# TR050007 Hinckley National Rail Freight Interchange

## Stoney Stanton Action Group

Comments on additional information supplied by TSH (10<sup>th</sup> Dec 2024) in response to the SoS's letter (10<sup>th</sup> Sep 2024)

5/2/2025

Appendix A Part 2 - Vehicle Tracking Sheet 1

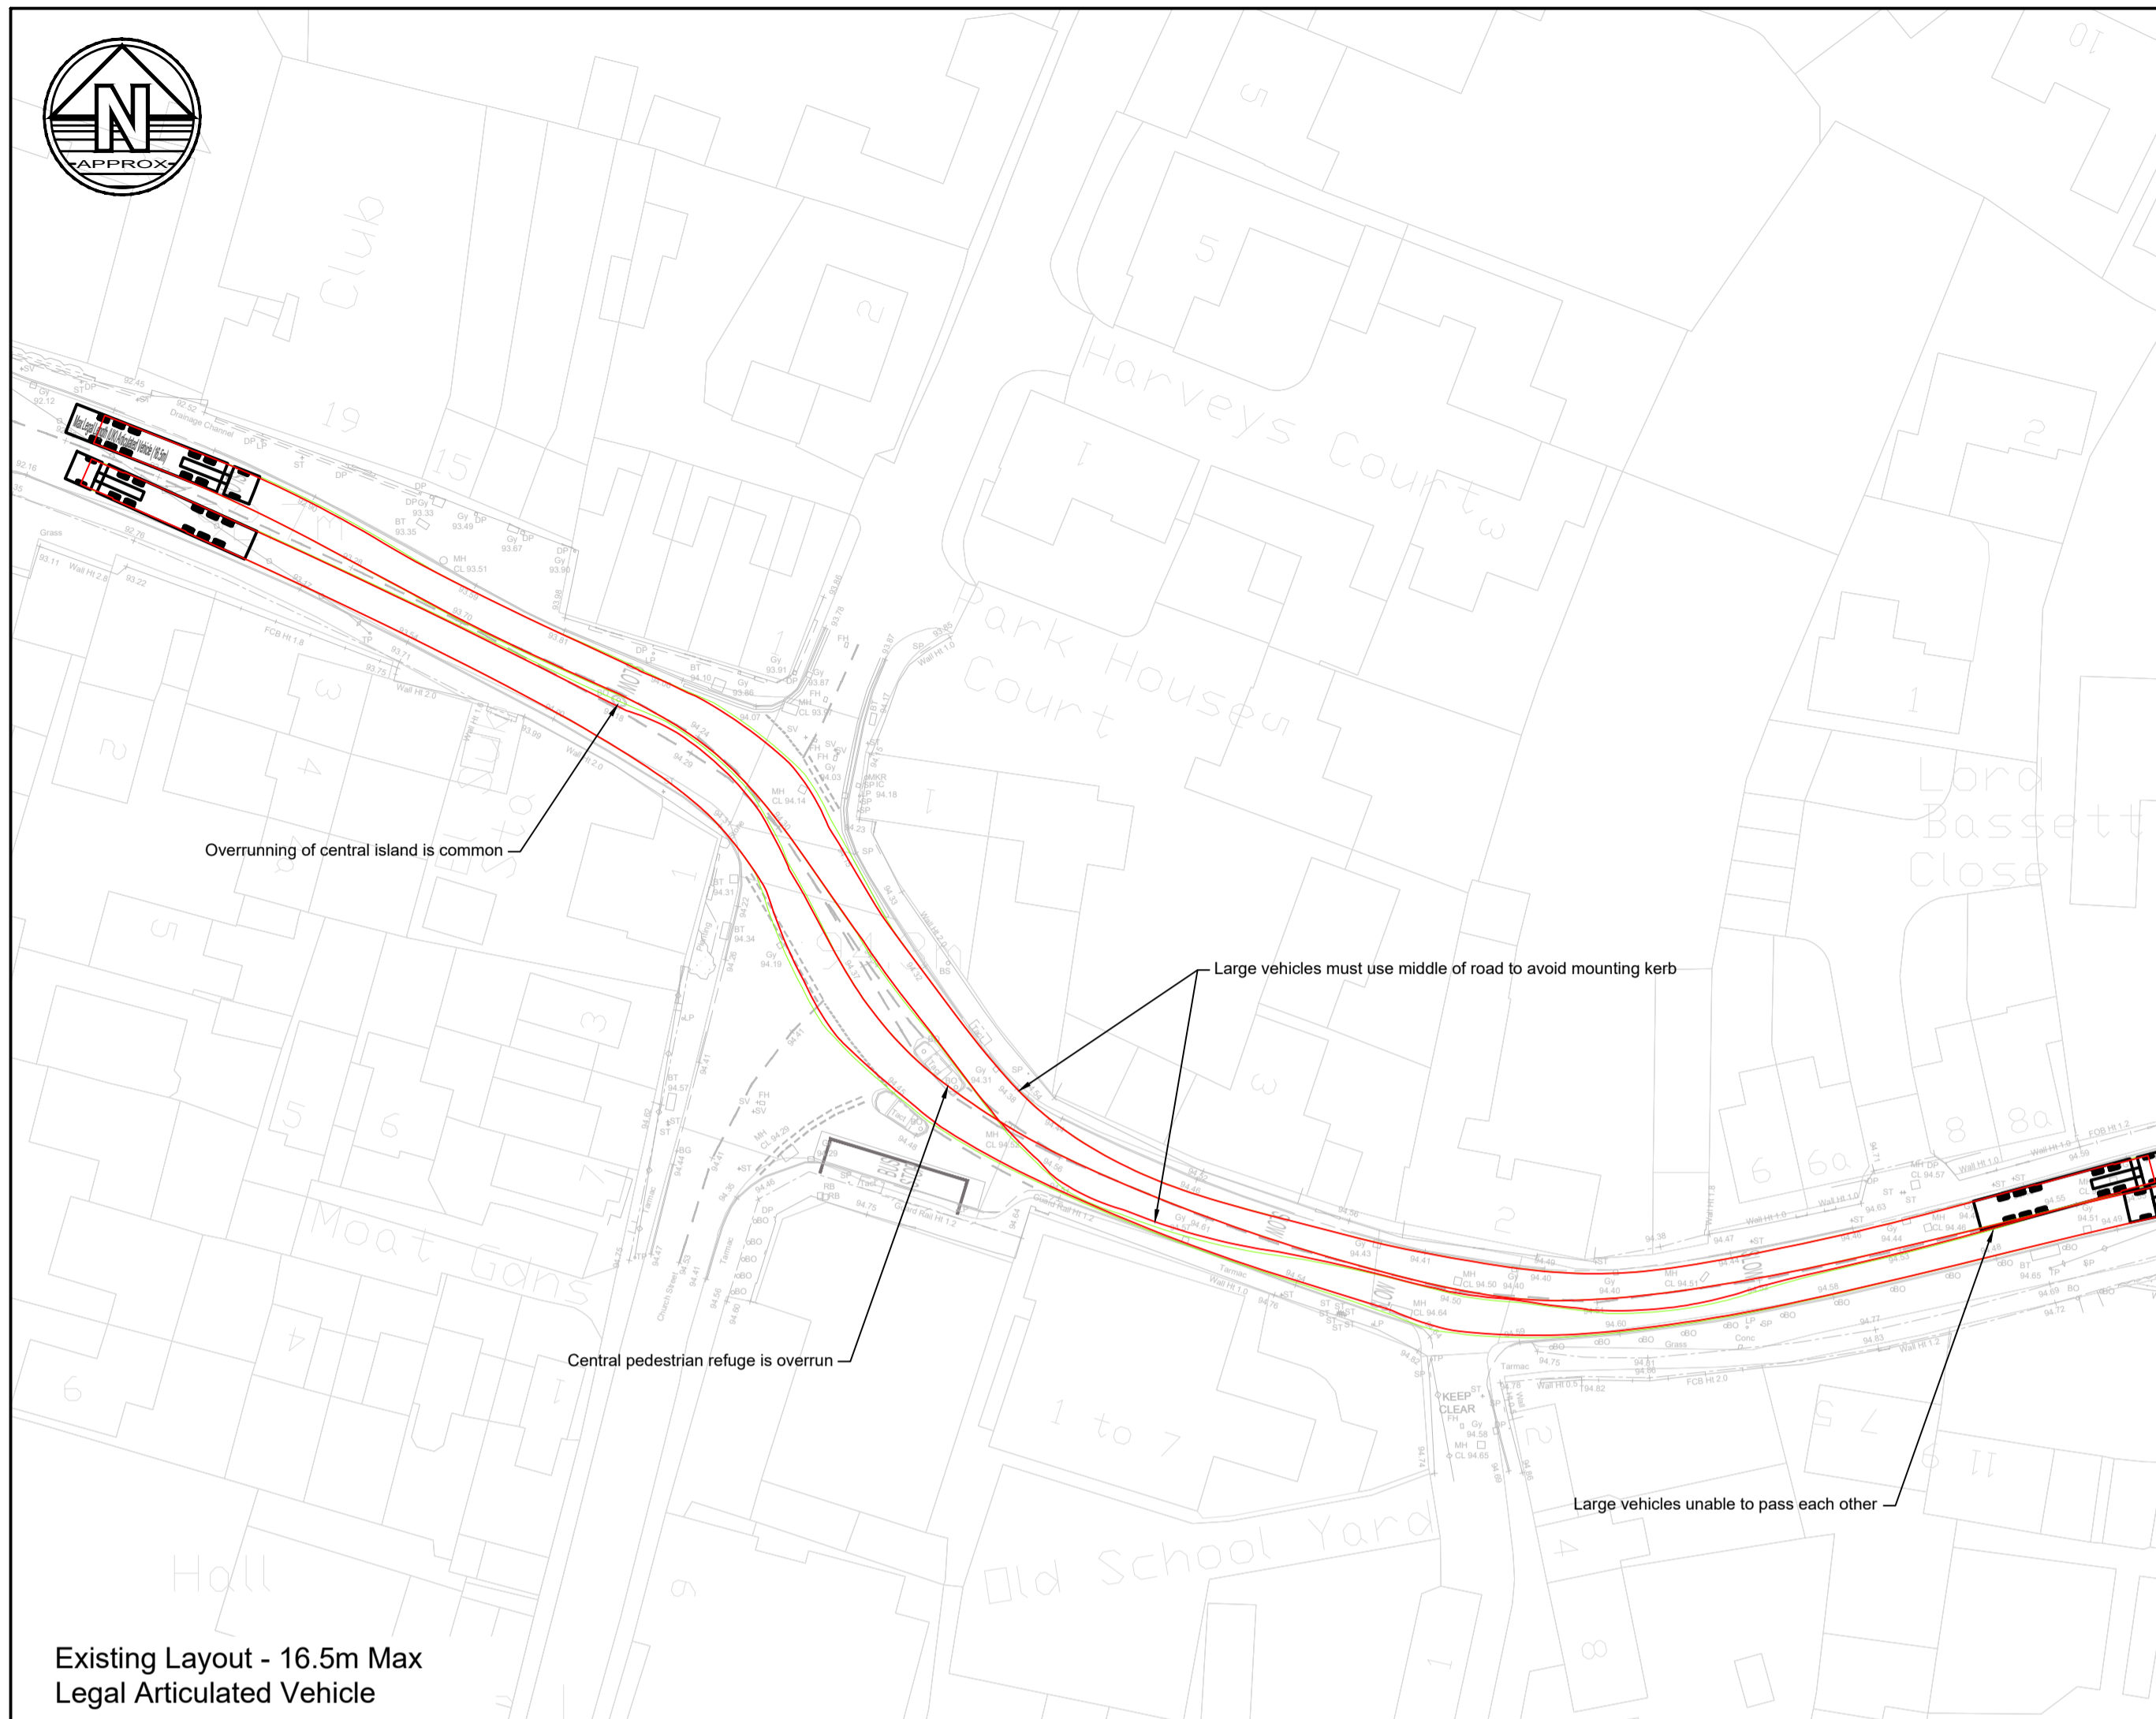
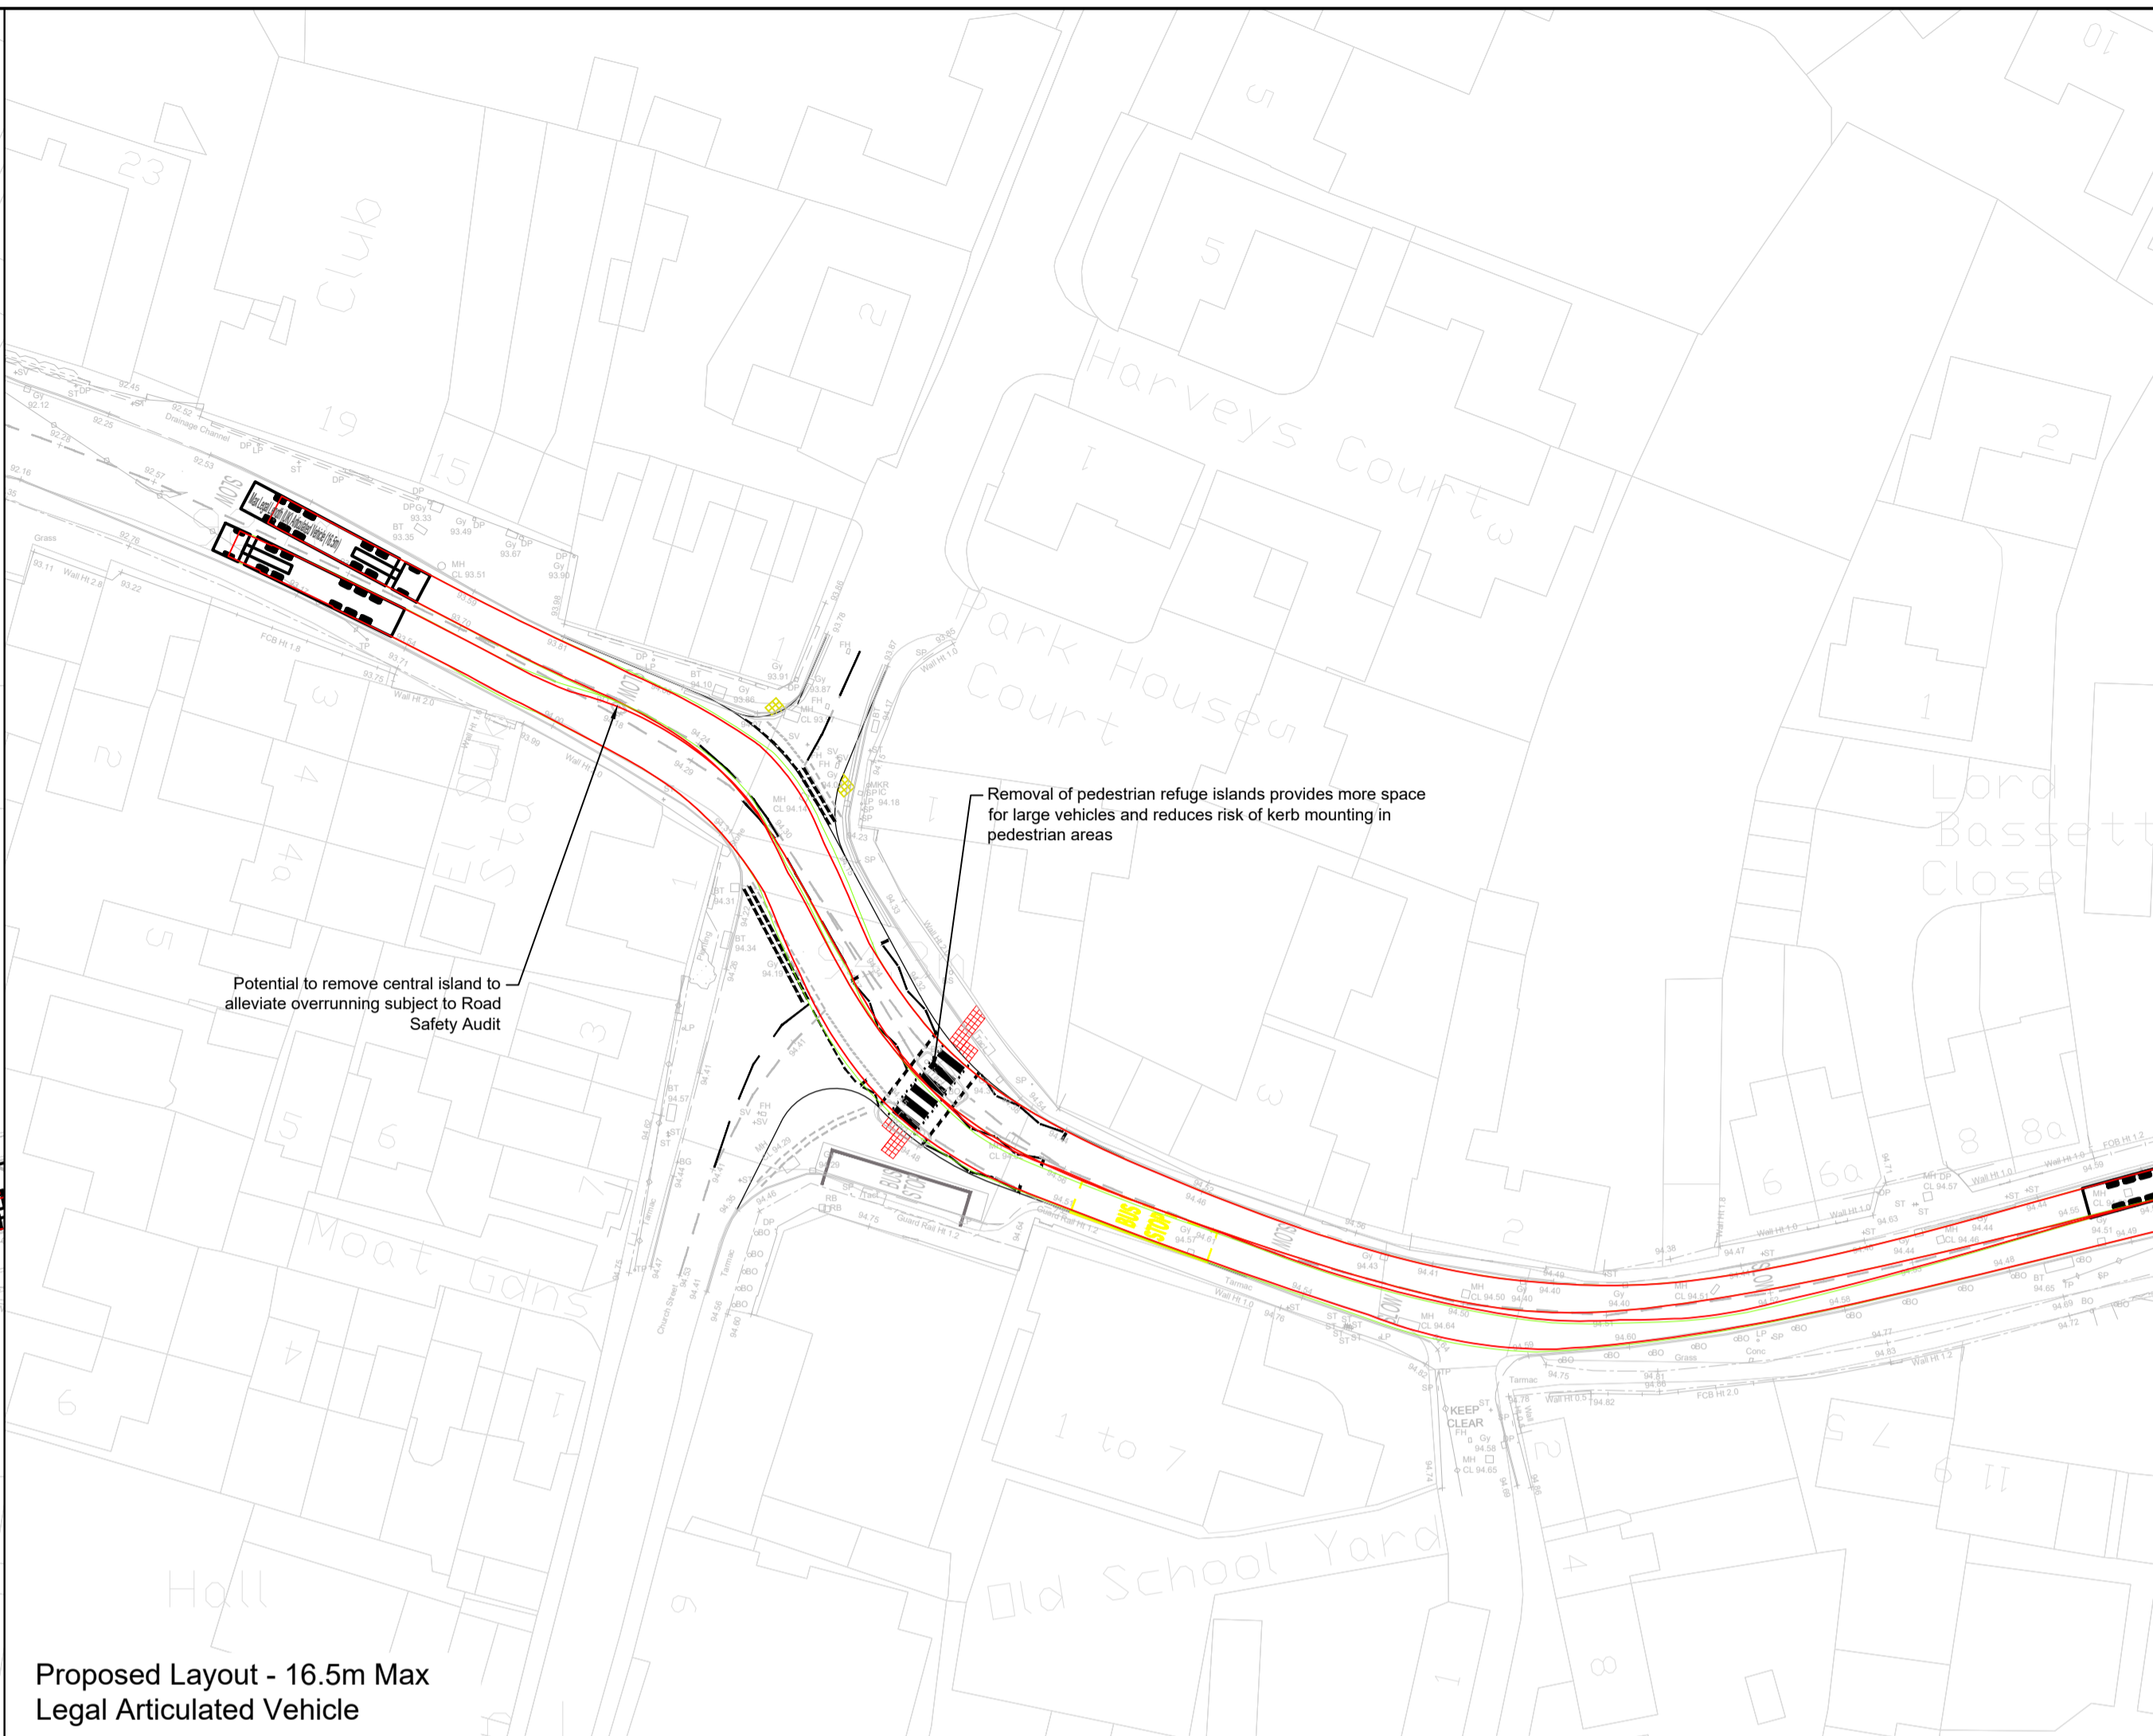
From a cursory read through "Appendix 2 - Sapcote Technical Note", another document that is overly dismissive of valid concerns. Table 2.1 in Section 2.12 of that document shows vehicle numbers for the B4669 to the West of the Co-op (Link 41) and to the East of the Co-op (Link 43). The HGV Annual Average Daily Traffic figures are inconsistent, for instance 2026 (scenario ii) Westbound is shown as 170 for Link 41 and 93 for Link 43. The difference is explained in section 2.13 by stating this shows that there is a significant proportion of local HGV traffic. From local knowledge it is easy to deduce that this is not likely, as all possible other destinations (e.g. Church Street and Stanton Road) are difficult to access by HGV. Additionally Westbound traffic for the Western Link (Link 41) increases by 10 in 2026 "with development", whereas the Westbound Traffic for Eastern Link (Link 43) increases by 1 in 2026 "with development". Either the HNRFI is creating additional local HGV traffic or the table is wrong. See photos in this document Section 4.
